**One Earth ISH 2 Wednesday 3 September-Thursday 4 July 2025**

Summary of Verbal Representations from Newark and Sherwood District Council (NSDC)

Figure 11.1: Site Location and Study Area

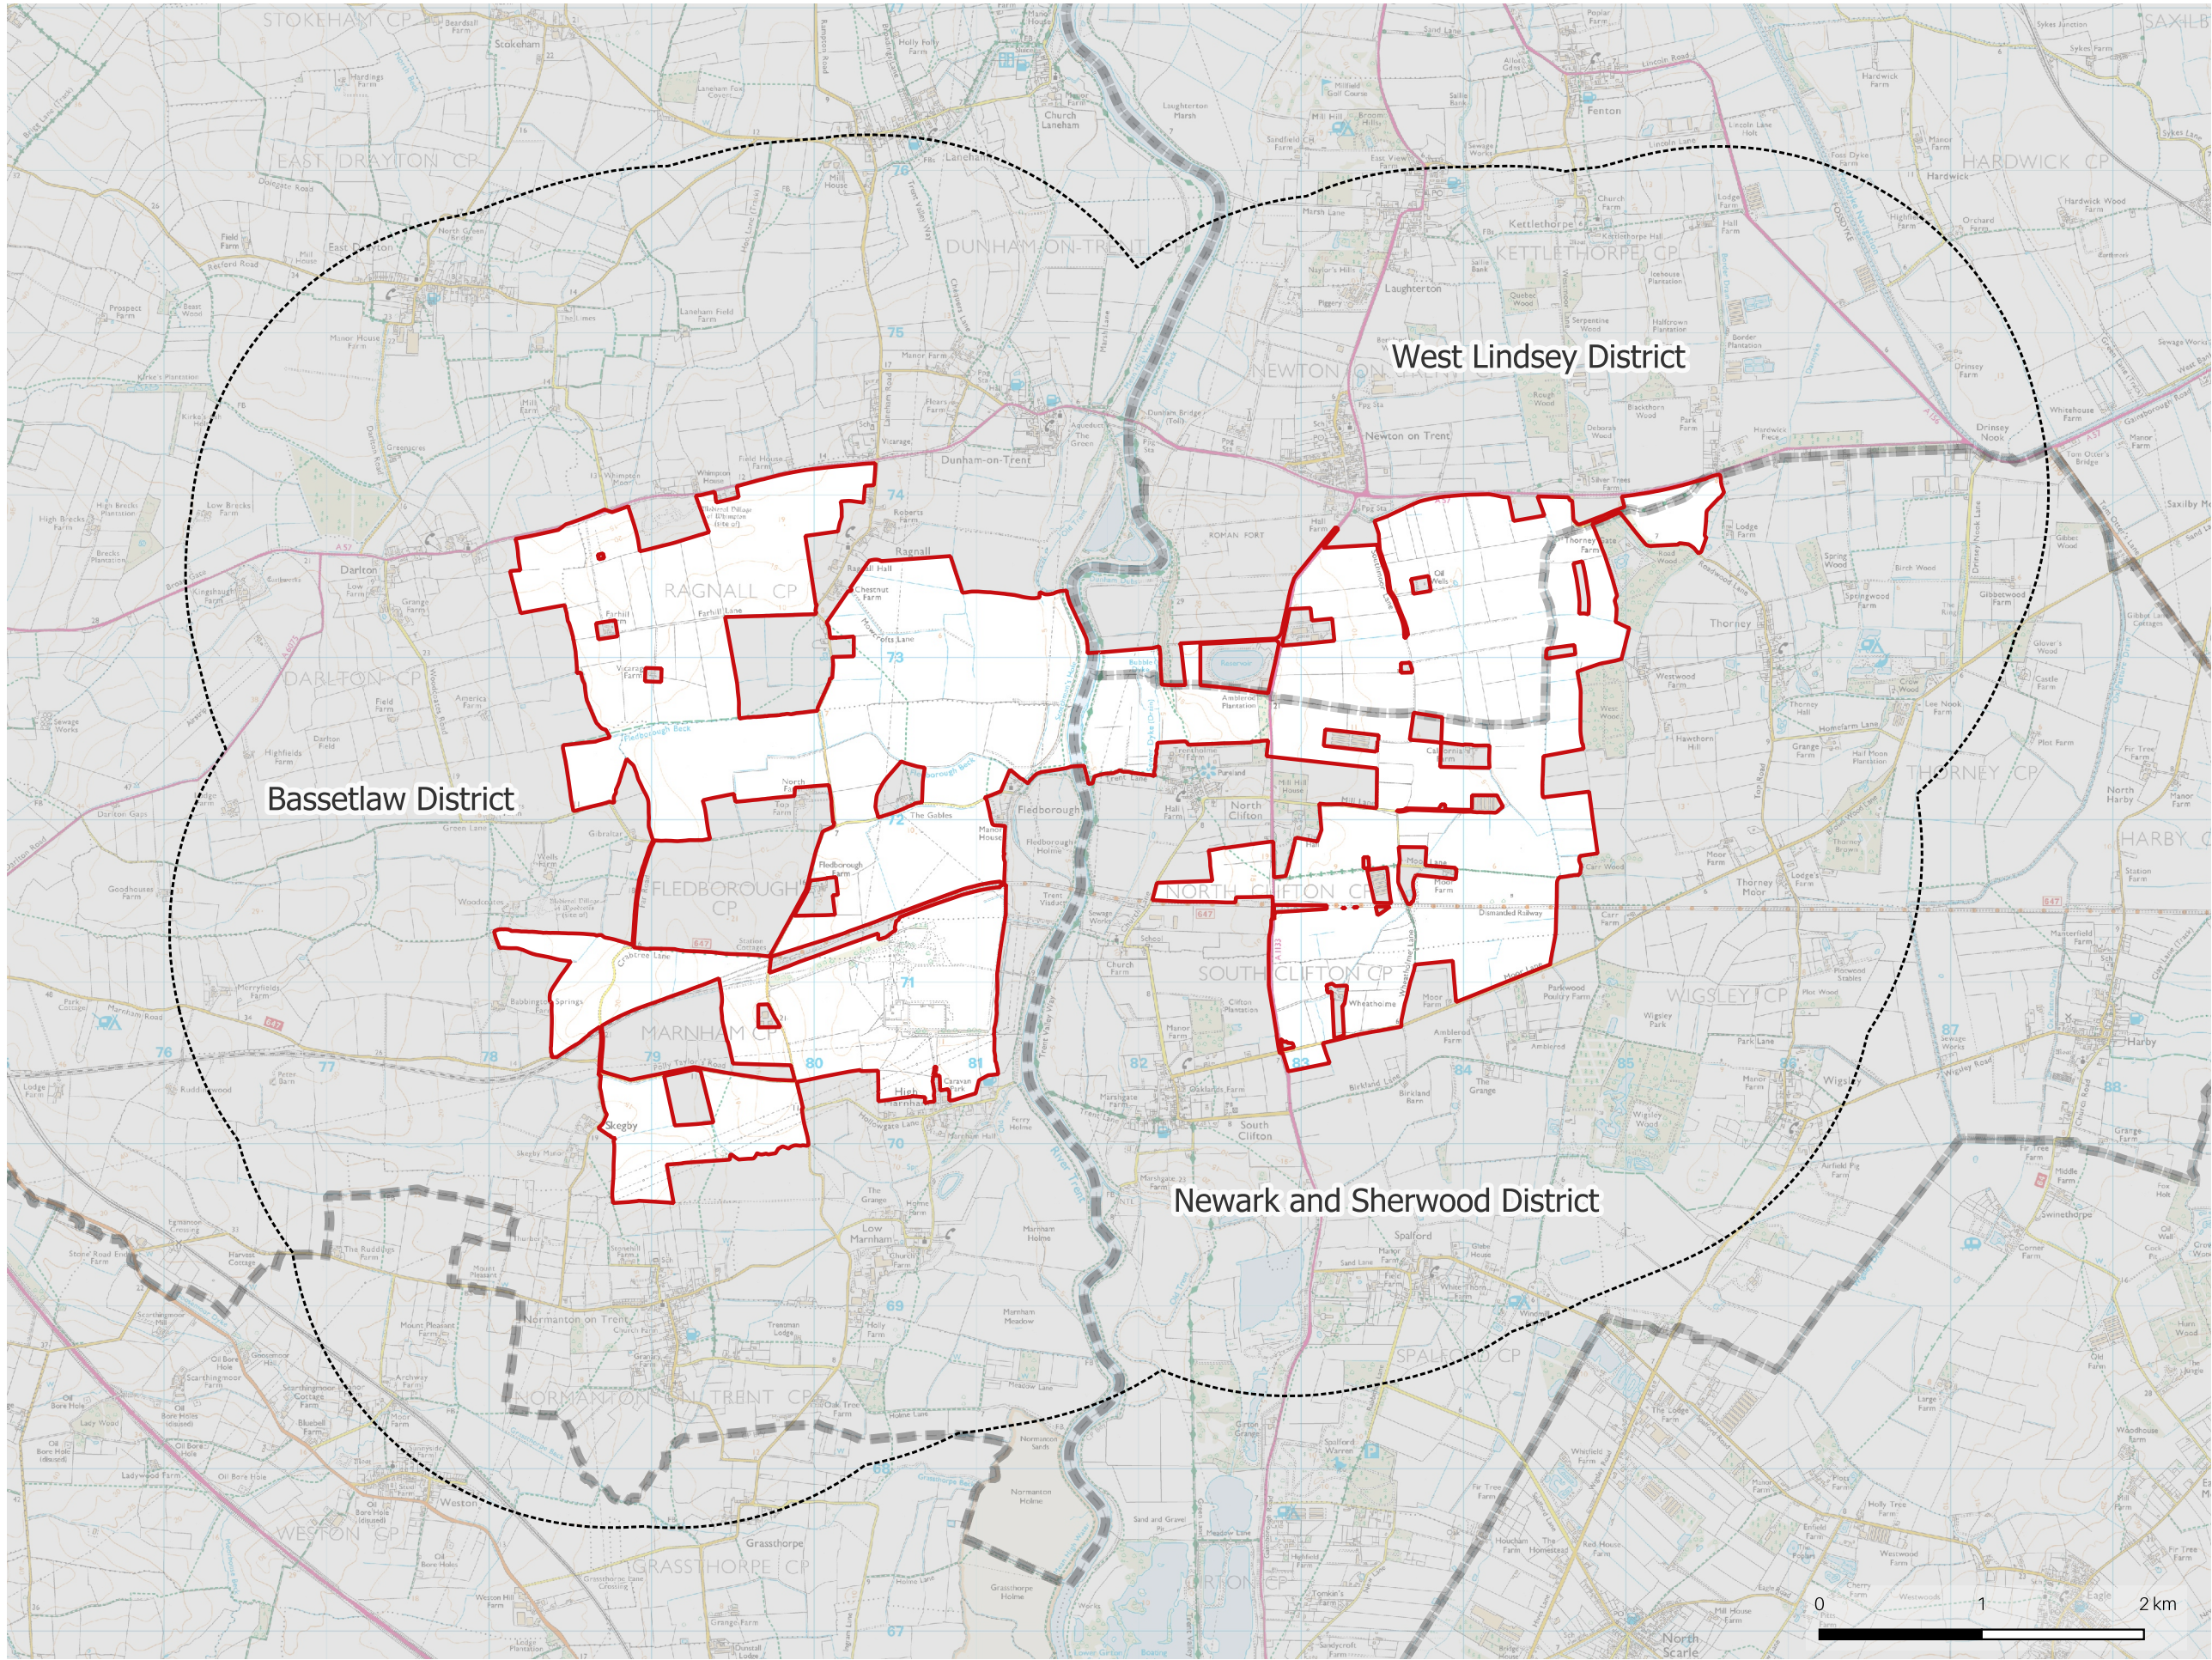
1. Under **Agenda Item 4 (i)**, in regard to the suitability of a 2km search area and a broader understanding of the effect on landscape character areas: We have not identified anything on Site or wider landscape that would contradict the statement made by the applicant that there would not be Significant effects of the One Earth scheme in isolation beyond 2km, and typically distance reduces the likelihood of Significant effects occurring. Therefore, we agree that a 2km study area for the One Earth scheme in isolation is appropriate.
